# THE SHOP'S FILING NO. 1A AT MERIDIAN RANCH LOT 2B

## SITE DEVELOPMENT PLAN EL PASO COUNTY, COLORADO. FALCON, COLORADO

FILE NUMBER: PPR2322

DRAWING NO.
COVER
SITE DEVELOPMENT PLAN

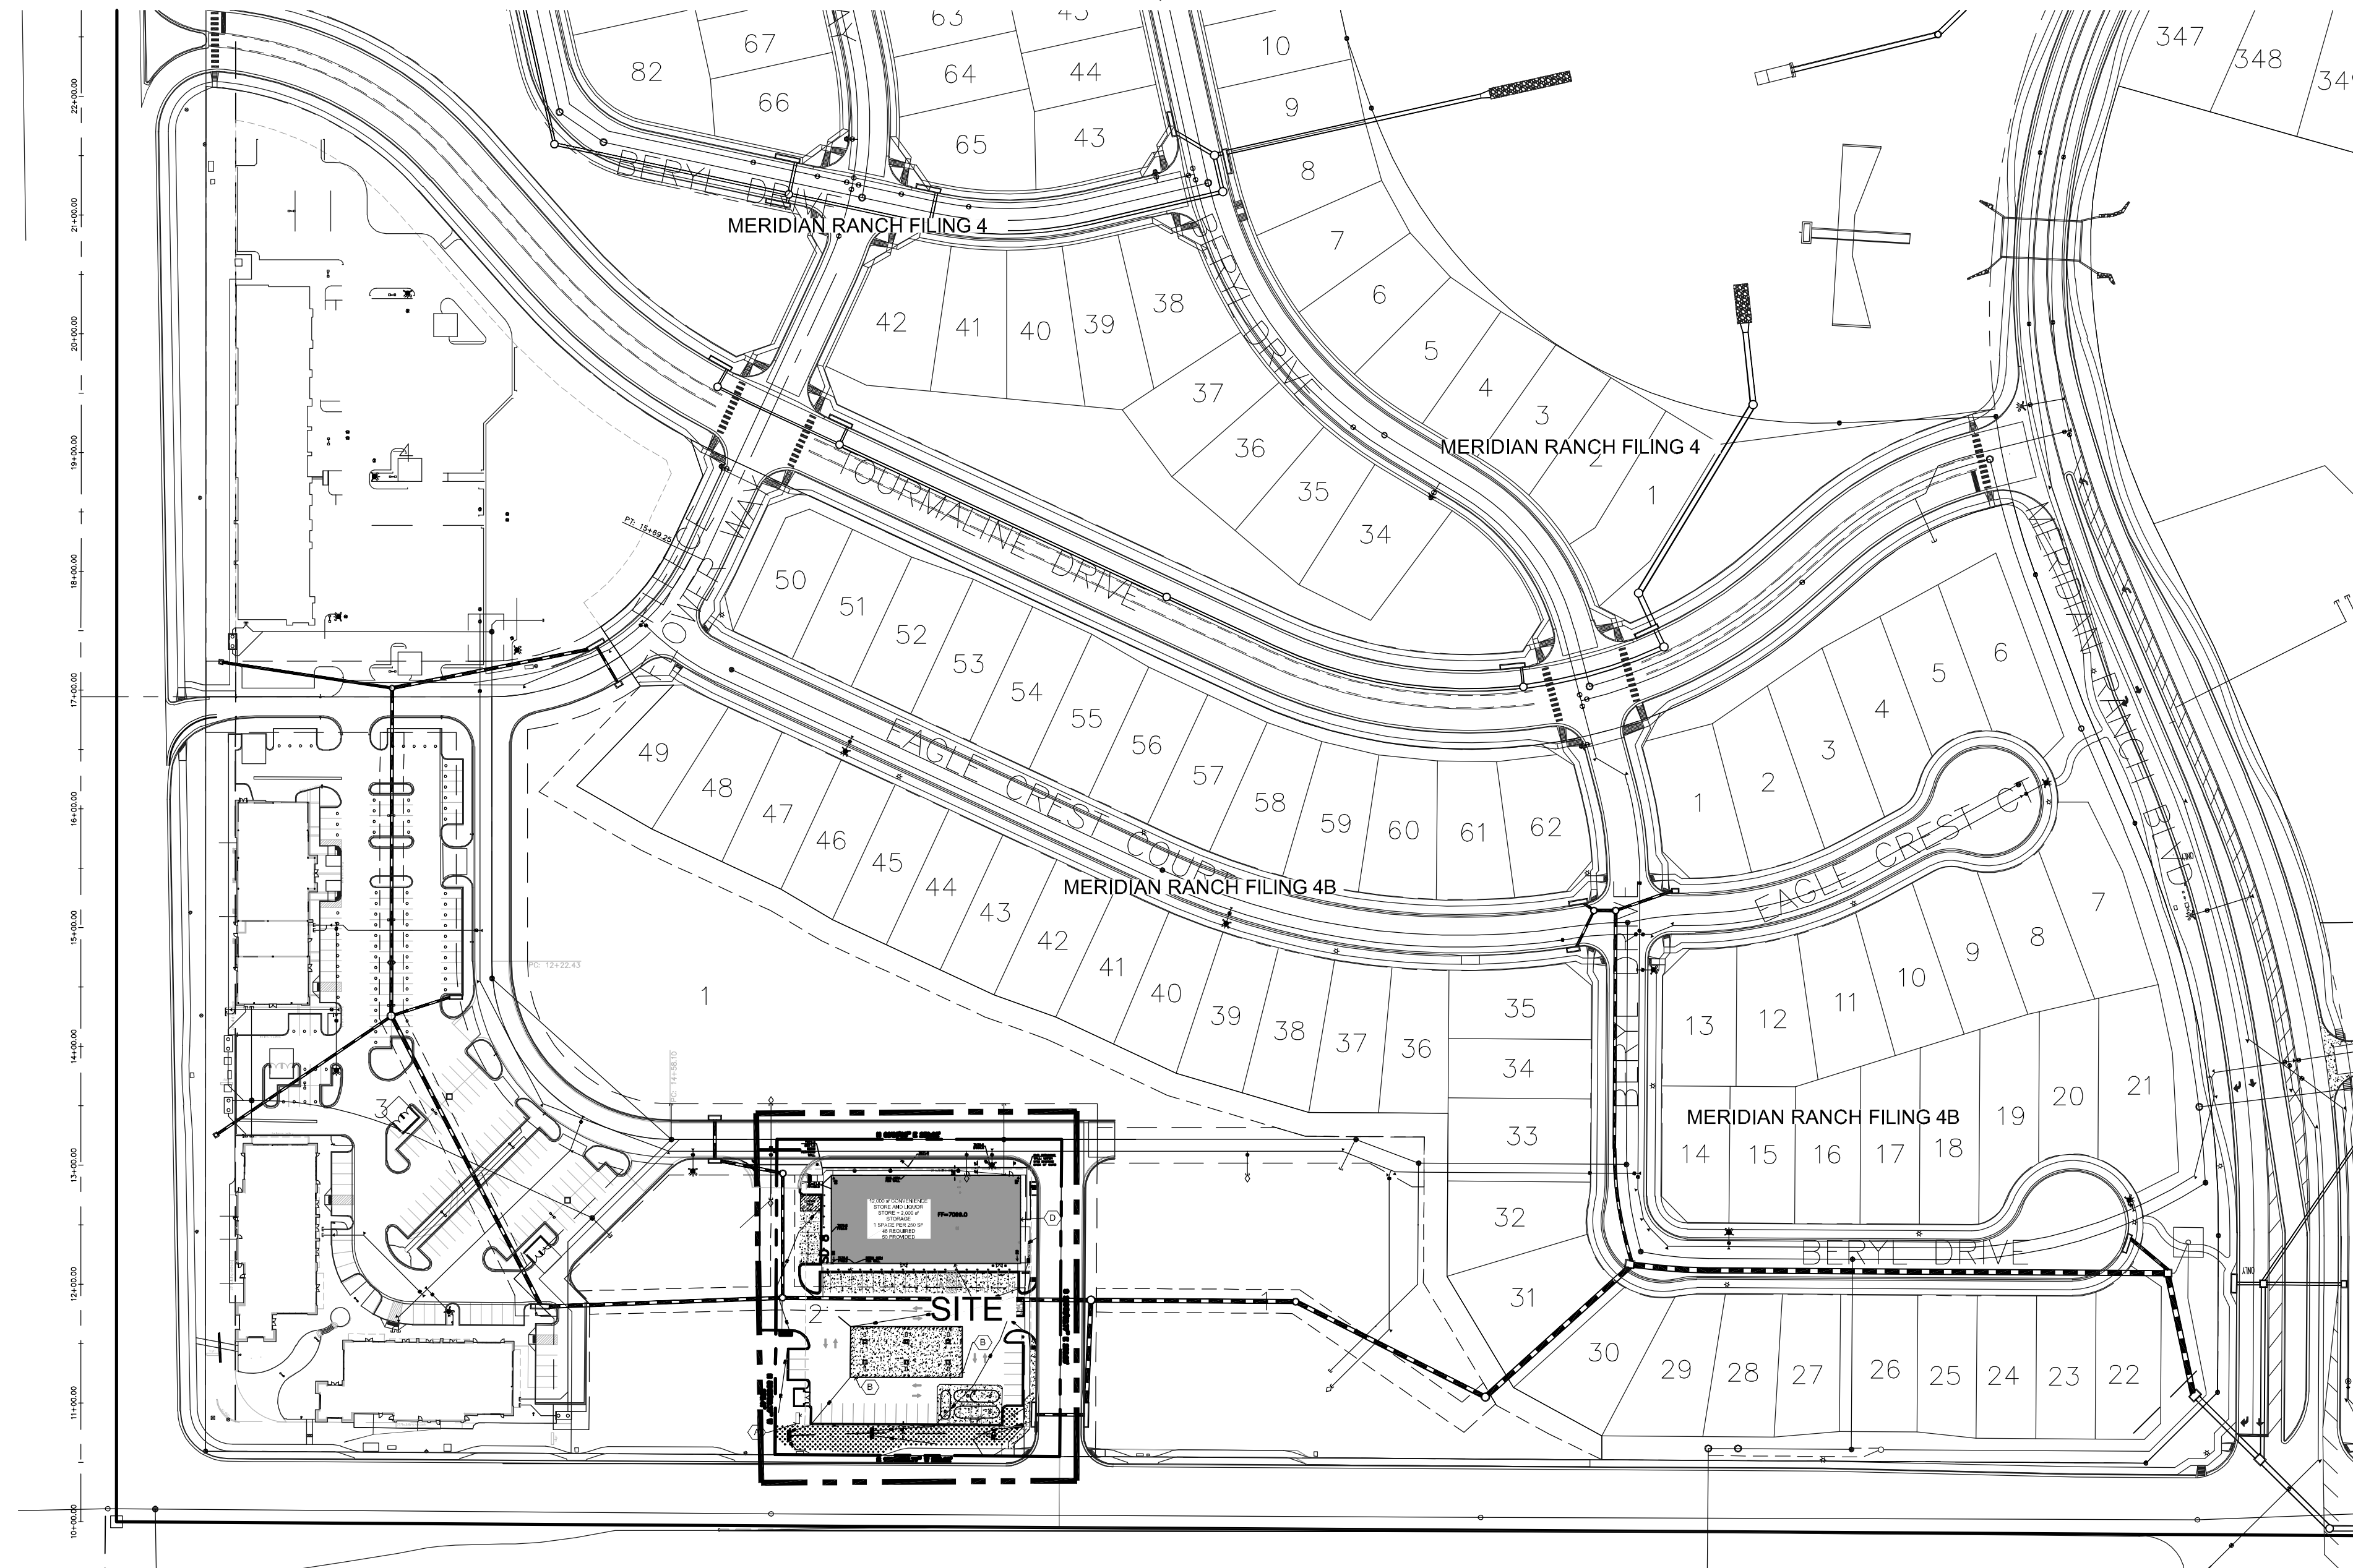
Shop's with an apostrophe is either a contraction or possessive. "The Shop is" or something belongs to the Shop.

The Shops (plural) does not need apostrophe.

Apologies for last round of review comment re: the title, but it was issued in error.

The title should be consistent with the subdivision name according to plat # 13659:

"The Shops Filing No. 1 at Meridian Ranch Lot 2B"

This is a site development plan so we're not changing the name of the subdivision with this application.

DRAWING NO. 1  
SITE DEVELOPMENT PLAN

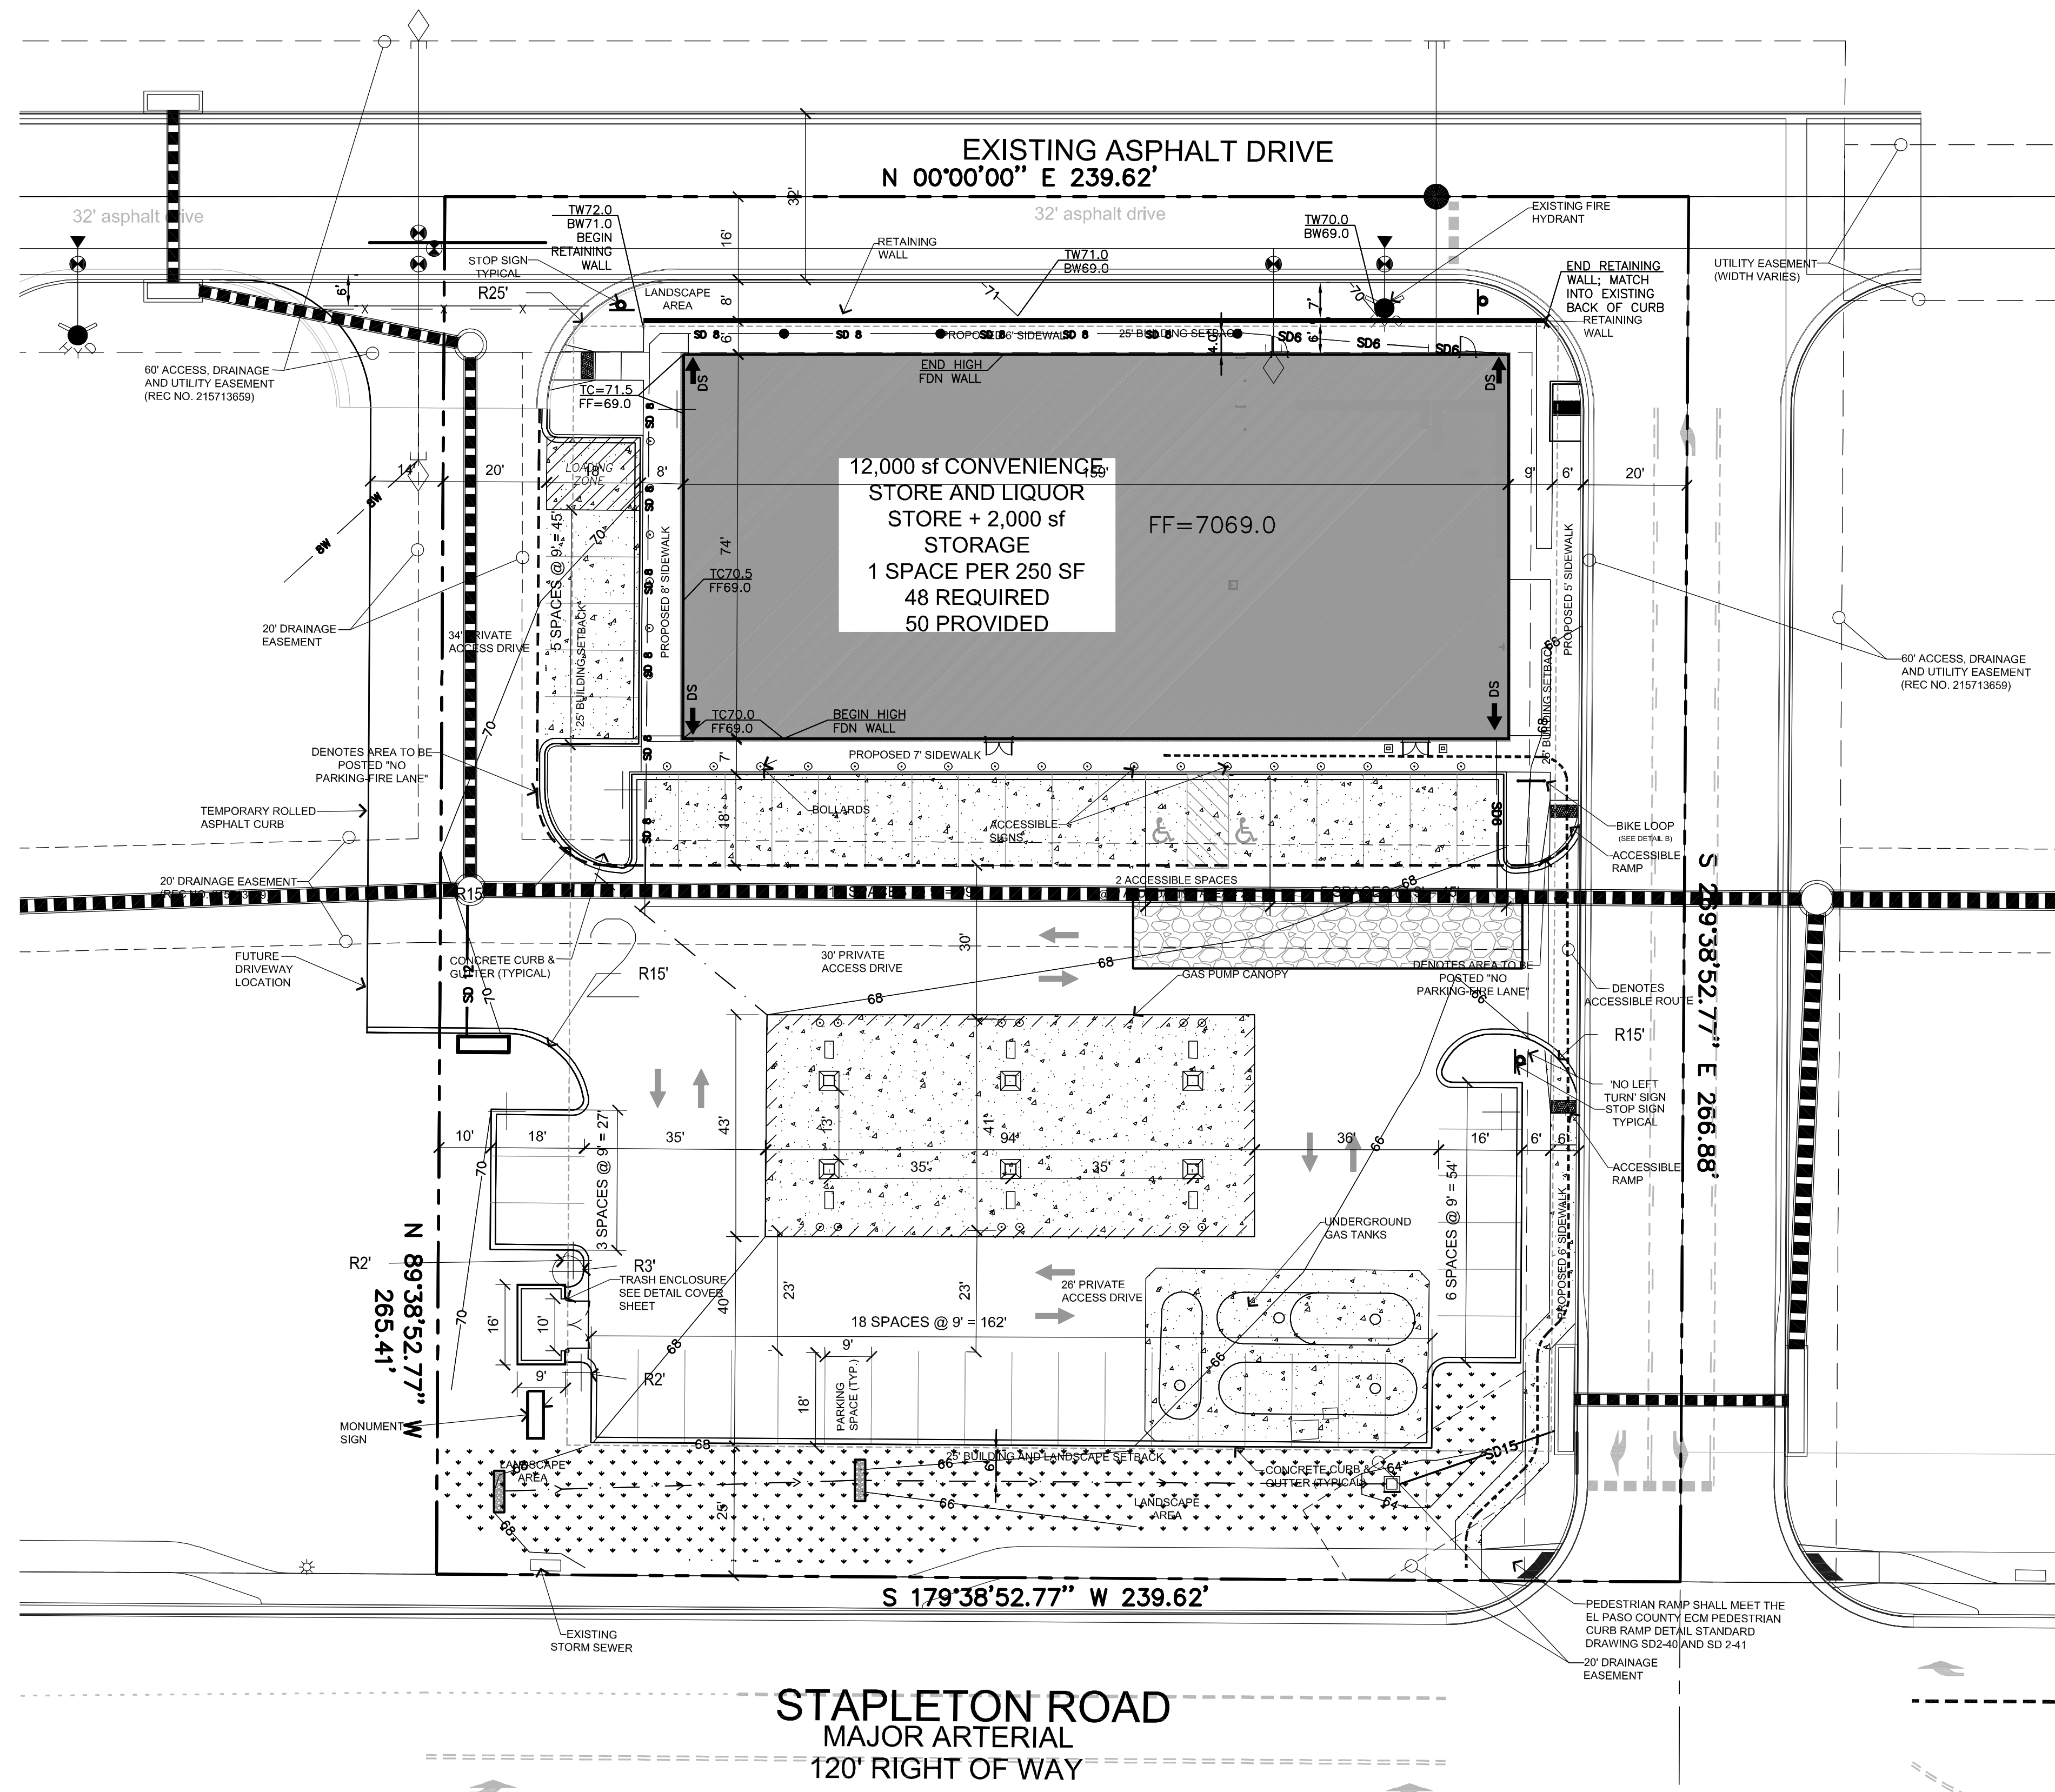
Please coordinate with traffic engineer and reflect any striping and signage required on the site development plan.
